RE : Application for Official Plan Amendment & Zoning By-Law Amendment
Place Lux (6770967 Canada Inc.)

Project : 1178 Cummings Ave. & 1098 Ogilvie Rd. (D01-01-19-0012/D02-02-19-0078)
N/D : 1712

This addendum letter has been prepared to address City of Ottawa comments received on March 24th, 2020 related to the Application for Official Plan Amendment & Zoning By-Law Amendment dated July 11th 2019 and deem completed January 14th, 2020. City comments are noted in black text, with the corresponding responses from Parsons provided in blue text.

SUBJECT LAND CONTEXT MAP SHOWING ST-LAURENT AND CYRVILLE TOD'S MAXIMUM HEIGHT AND MINIMUM DENSITY

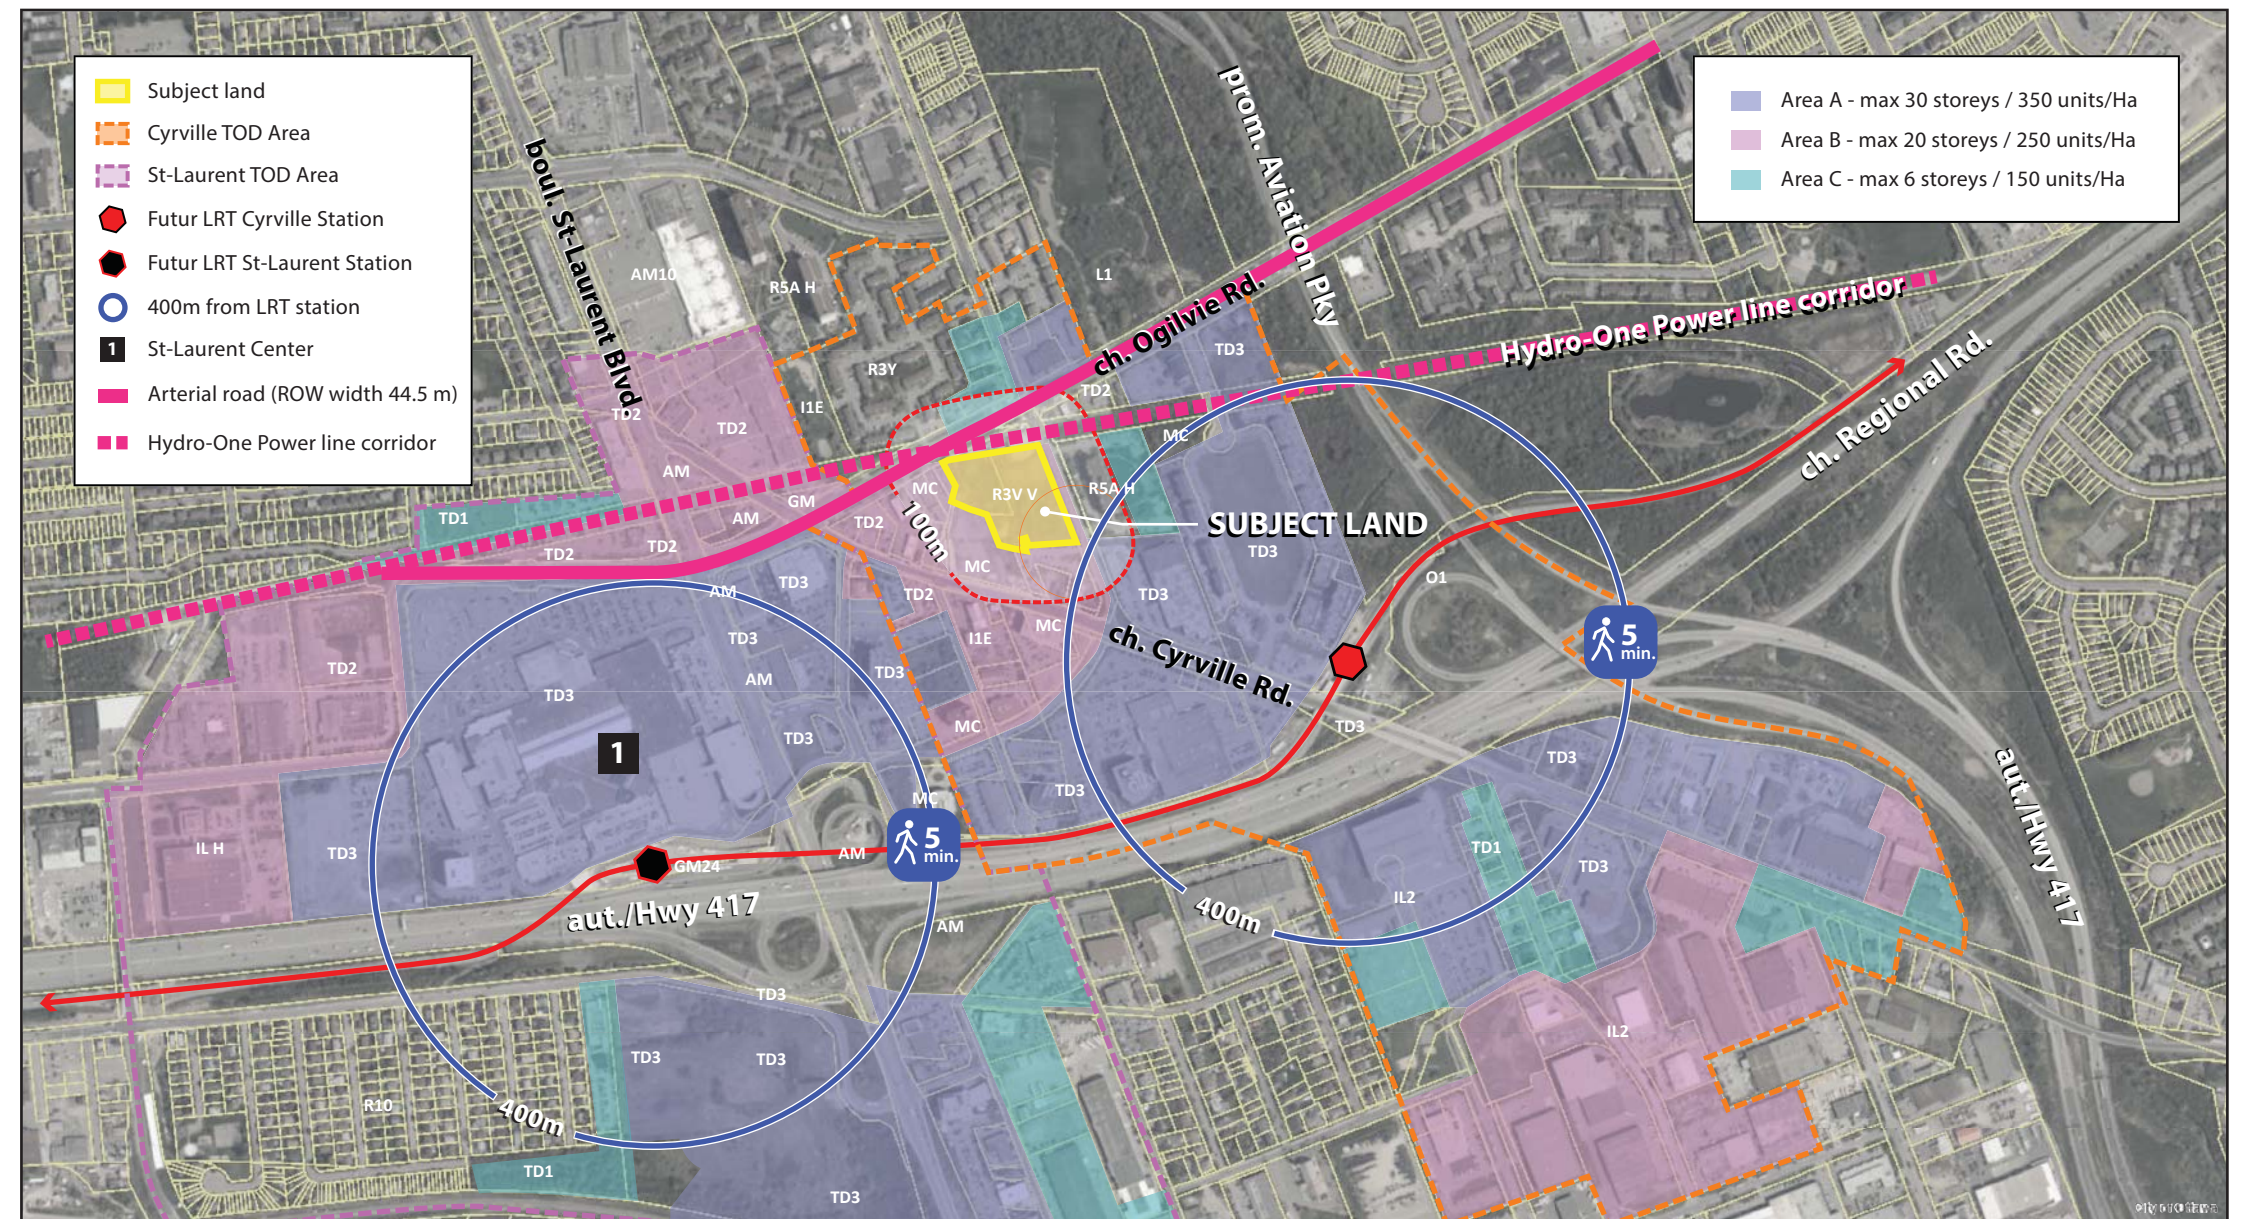
- a) a comprehensive assessment of the impacts of the proposed 30+ high-rise development on the surrounding area (e.g. the Secondary Plan area), outlined above.
- b) What would the area look like with the proposed building height and mass as compared to the current height regime established in the Secondary Plan? To help answer this question, a conceptual block plan, illustrations and 3D renderings of the area bounded by Ogilvie Road, Cummings Avenue and Cyrville Road should be submitted to illustrate the planned future

conditions established by the Secondary Plan as compared to the potential future conditions with the proposed 30+ high-rise development.

Noted. a) Please see response to these policy in point 1 above b) We produced a 3D model of the Cyrville and St-Laurent TOD area to illustrate the proposed building height and mass in a short-term. We also produce a conceptual block plan to illustrate the planned future conditions established by the Secondary Plan as compared to the potential future conditions with the proposed 30+ high-rise development. (Appendix A)
